**LORSON RANCH  
AT  
JIMMY CAMP**

**SKETCH PLAN NARRATIVE**

October 2003

MINOR SKETCH PLAN AMENDMENT #2

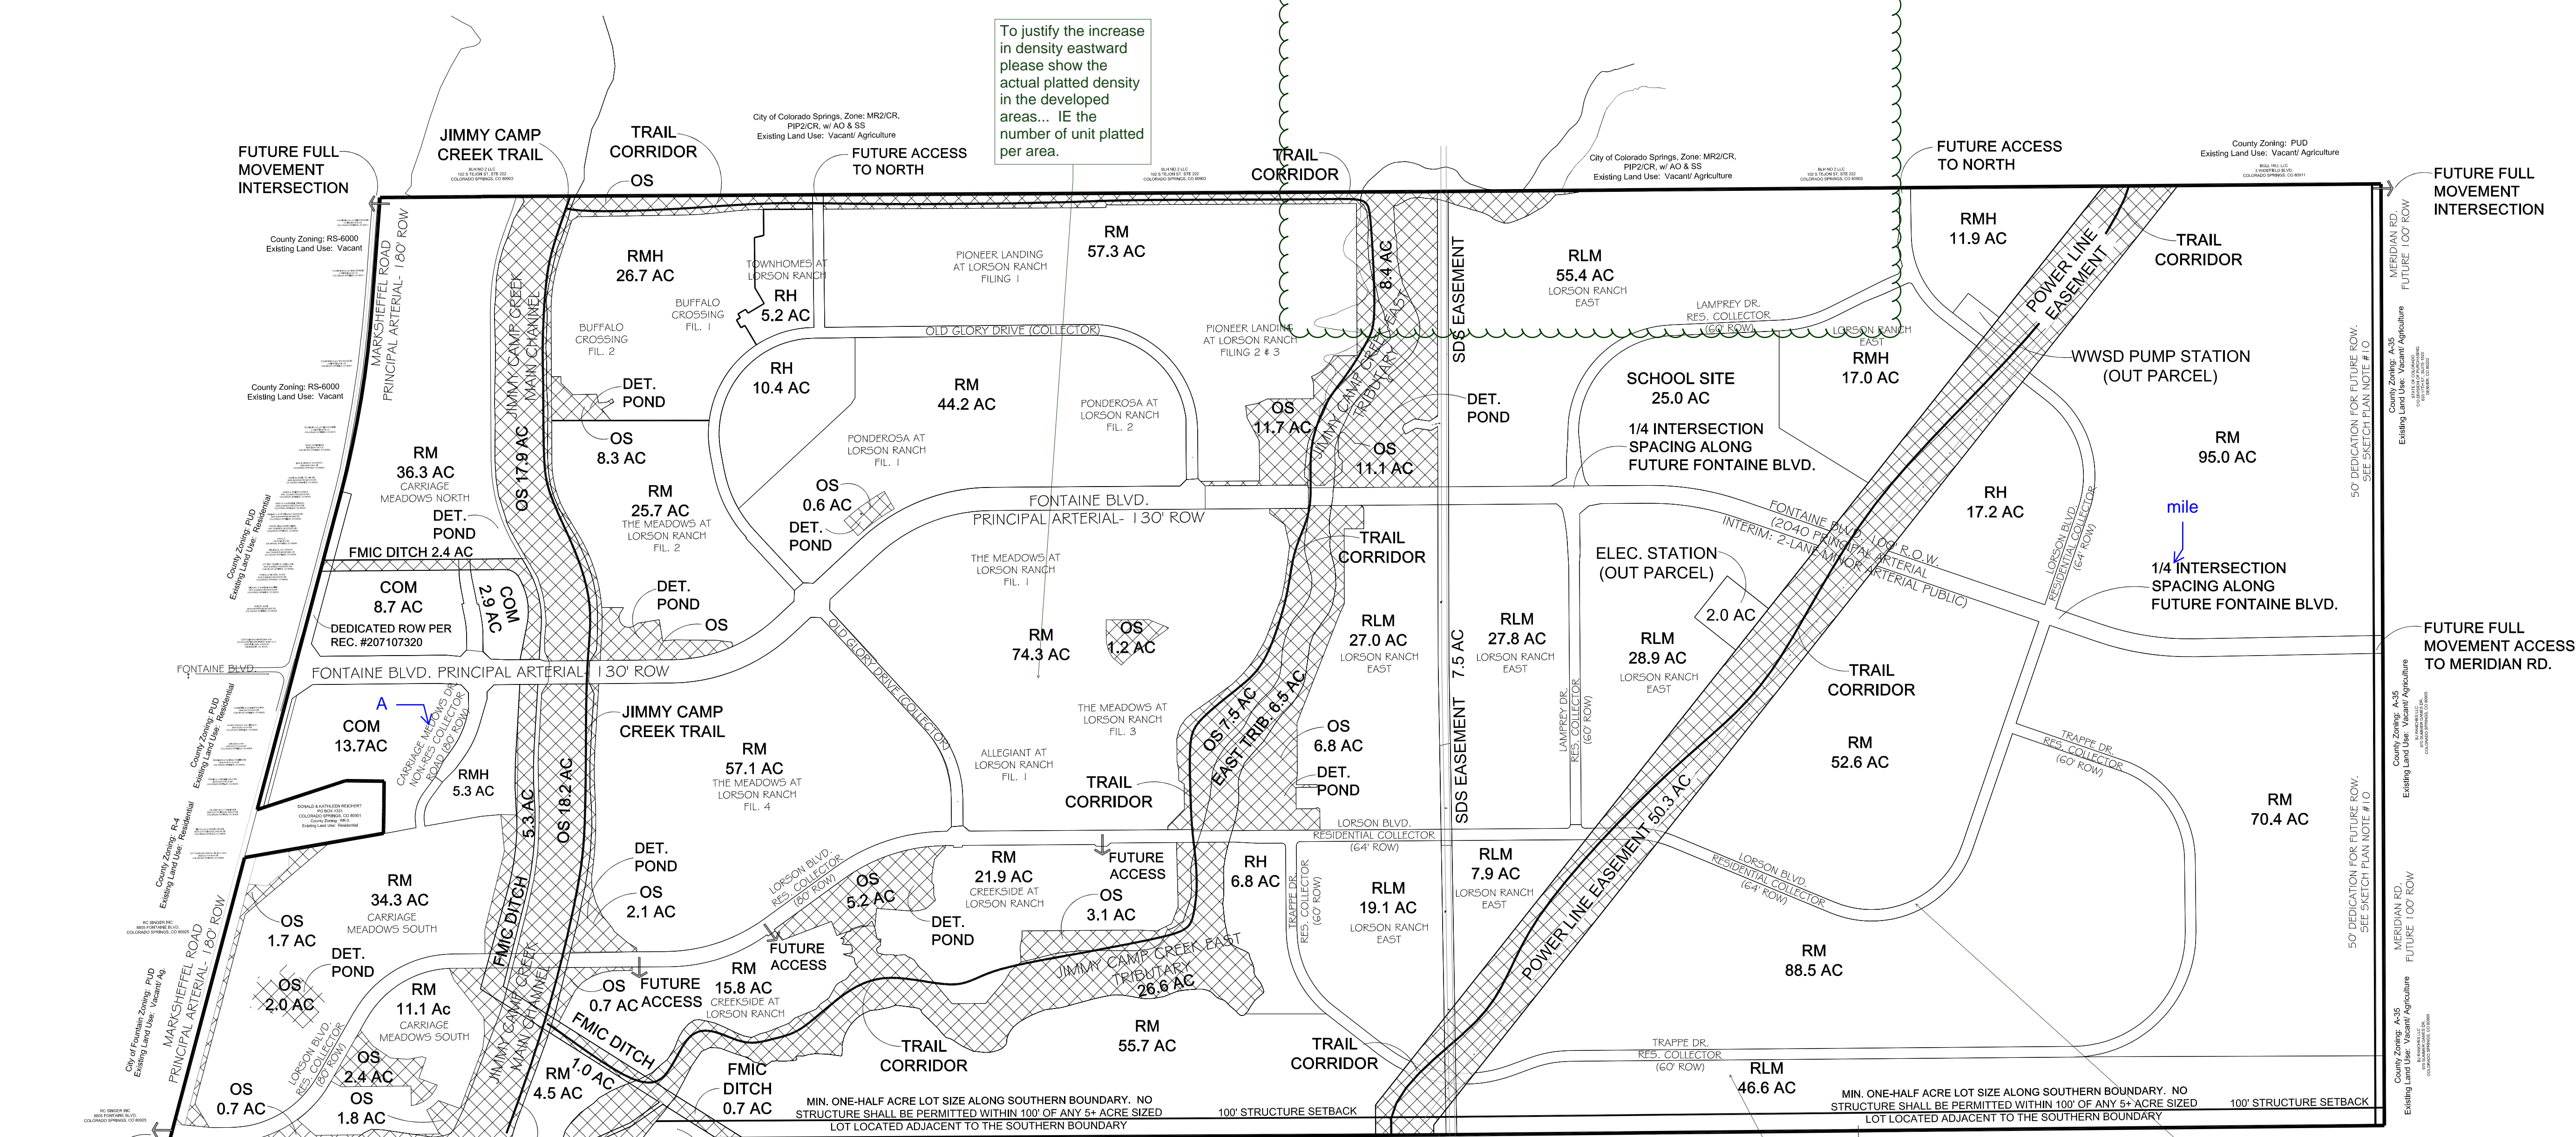
Provide an addendum with this plan addressing the changes referenced by cloud depicted on the skp plan to ensure minimal impacts
